RE: Wilson Creek Short plat submission fee received (receipt #1228)

Thank you for the opportunity to comment on the short plat of 6.55 acres into 2 lots, proposed by Mike Smith [SP 08-00027]. We have reviewed the application and have the following comments.

TO: Trudie Pettit, CDS
FROM: Christina Wollman, Planner II *cw*
DATE: July 15, 2008
SUBJECT: Additional Information Requested
Wilson Creek Short Plat SP-08-27

TO: Community Development Services
FROM: Christina Wollman, Planner II *W*
DATE: December 17, 2008
SUBJECT: Wilson Creek Short Plat SP-08-27

WILSON CREEK SHORT PLAT
 PART OF SEC. 29, T. 18 N., R. 19 E., W.M.
 KITTITAS COUNTY, WASHINGTON

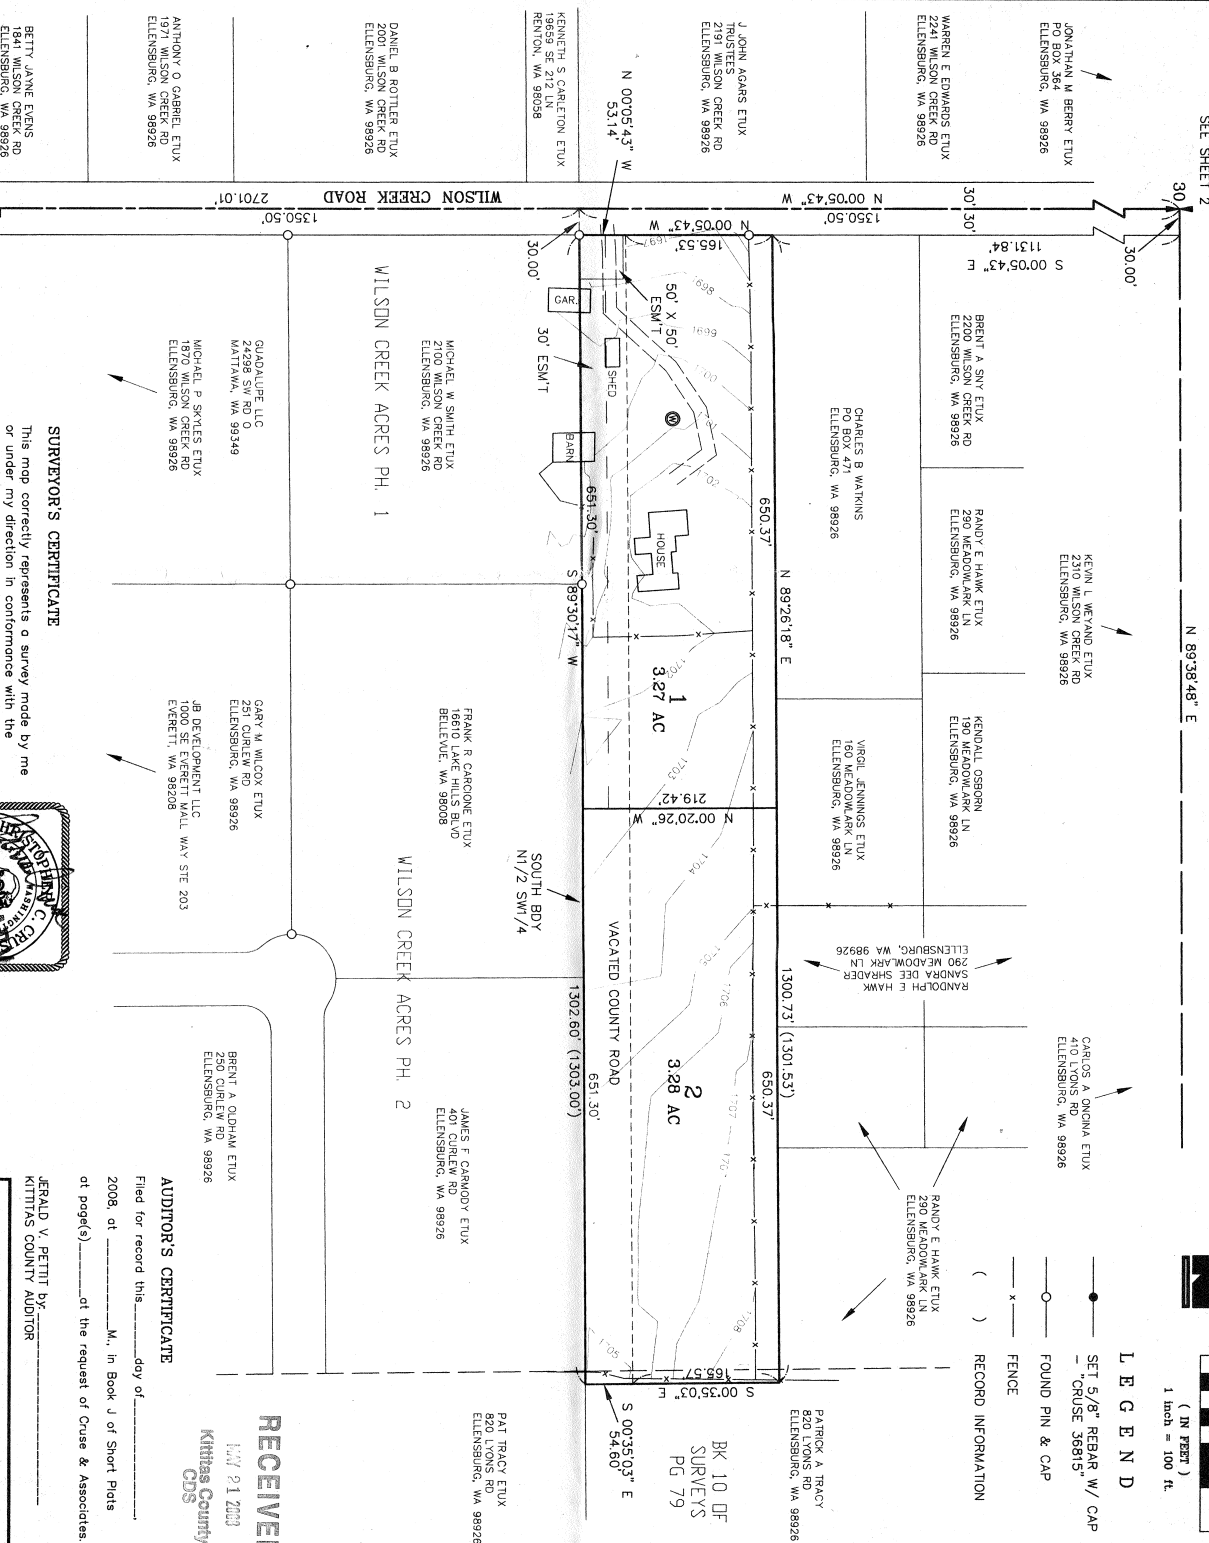
Kittitas County Road Standards require all accesses that serve three or more lots be constructed as a private road and end in a cul-de-sac. The access serving the Wilson Creek Short Plat will serve three lots and requires a turnaround. The applicant shall provide more info regarding the placement of a turnaround. If a hammerhead is proposed, a variance will be required.

1. Access: All access shall be from the existing access. Per the attached letter from Brenda Larson, Fire Marshal, no turnaround will be required due to the driveway configuration. A paved apron at least 20' in width shall be required.
2. Joint-Use Driveway: A joint-use access shall serve no more than two tax parcels. See Kittitas County Road Standards, 9/6/05 edition.
 - a. Access easements shall be a minimum of 20' wide. The roadway width shall have a minimum width of 12'.
 - b. The surface requirement is for a minimum gravel surface depth of 6”.
 - c. Maintenance of driveway approaches shall be the responsibility of the owner whose property they serve. The County will not maintain accesses.
 - d. Any further subdivision or lots to be served by proposed access may result in further access requirements.
